CITY OF ALBUQUERQUE

January 8, 2021

Re: Street Front Improvements
1921 Bellamah
Traffic Circulation Layout
Engineer's/Architect's Stamp 1-6-2021

1921 BELLAMAH AVE NW ALBUQUERQUE, NM		DRAWN BY pm
	SITE PLAN		DATE 8-1-22
 7-6-22 RONALD R. BOHANNAN P.E. #7868			SHEET # SP-1
	5571 MIDWAY PARK PL NE ALBUQUERQUE, NEW MEXICO 87109 (505) 858-3100 www.tierrowestllc.com		JOB # 2022047

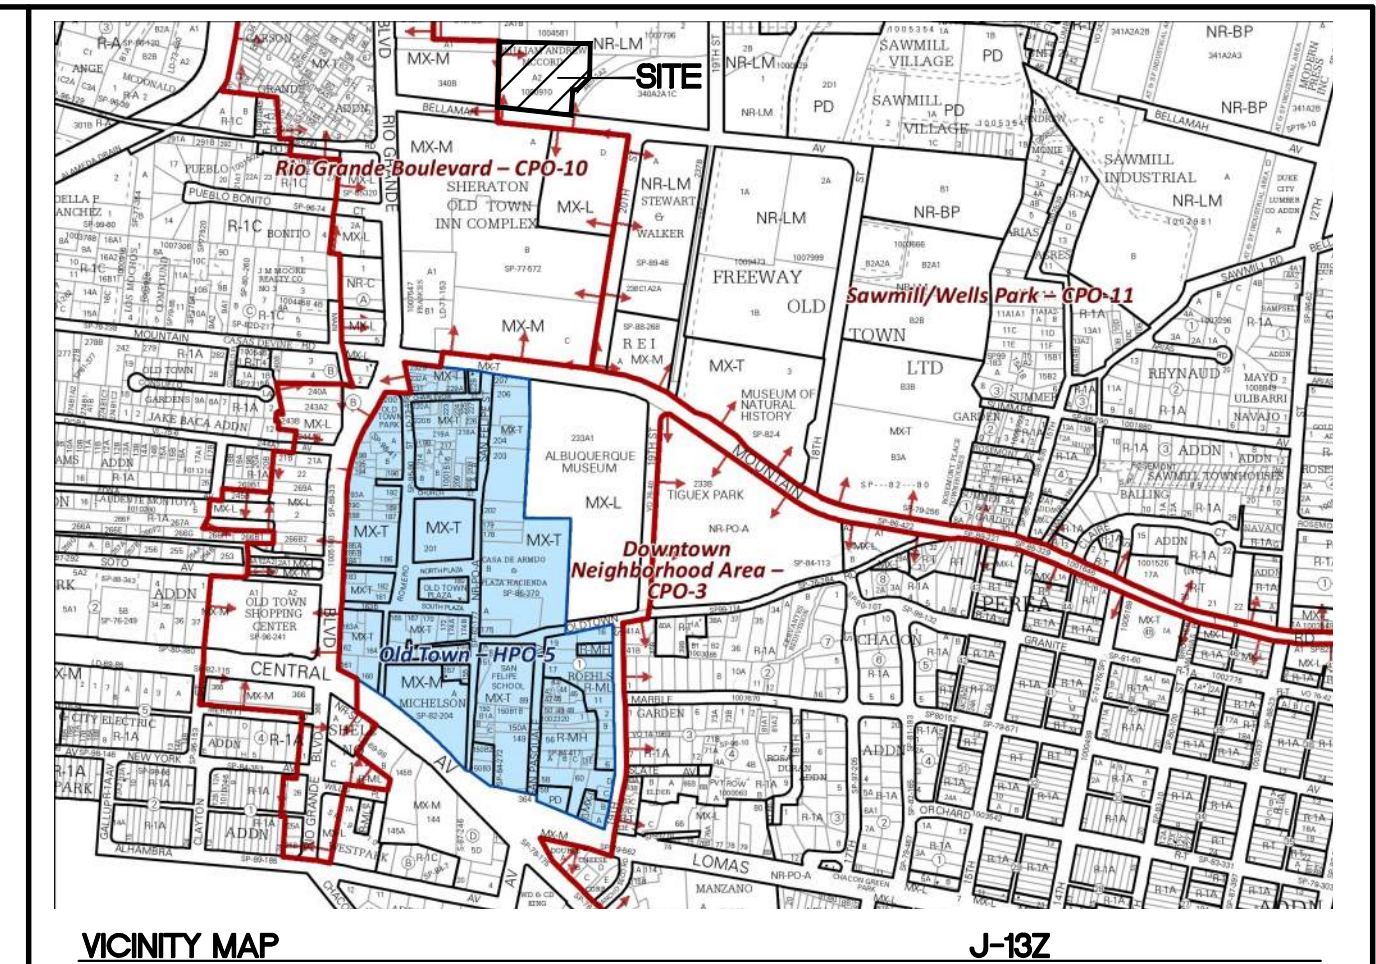
1. Provide a dimension on site plan drawing showing distance from face of curb to face of curb on Bellamah. Underneath dimension state, "Match Existing".

2. Call out standard City Drawings for curb and sidewalk. Use standard curb that matches the existing curb on-site and not header curb.
3. Provide note stating to tie to existing curb and match flowline on each end. Provide a general note for new curb to match existing curb elevations.

4. How do the driveway locations line up with the current site layout, and how do they line up with driveways across the street? Include these existing conditions to show circulation in and out of the site with minimal conflict.

5. Revise the cross-section of the new curb and sidewalk showing a maximum 2% cross-slope for the sidewalk, the distance between the curb and sidewalk, the sidewalk width, and the distance between the new curb and existing curb across the street. Lip of curb shall be flush with asphalt pavement and capture street drainage.

6. For the driveways, show a 2% maximum slope across the driveway for a minimum distance of 4 feet that lines up with the curb ramps. Show driveway slope on the other portion of the driveway as applicable.

7. Show clear sight triangle on landscaping plan in addition to site plan and include the standard note. The landscaping may need to be adjusted to meet these requirements. "Landscaping and signage will not interfere with clear sight requirements. Therefore, signs, walls, trees, and shrubbery between 3 and 8 feet tall (as measured from the gutter pan) will not be acceptable in the clear sight triangle."
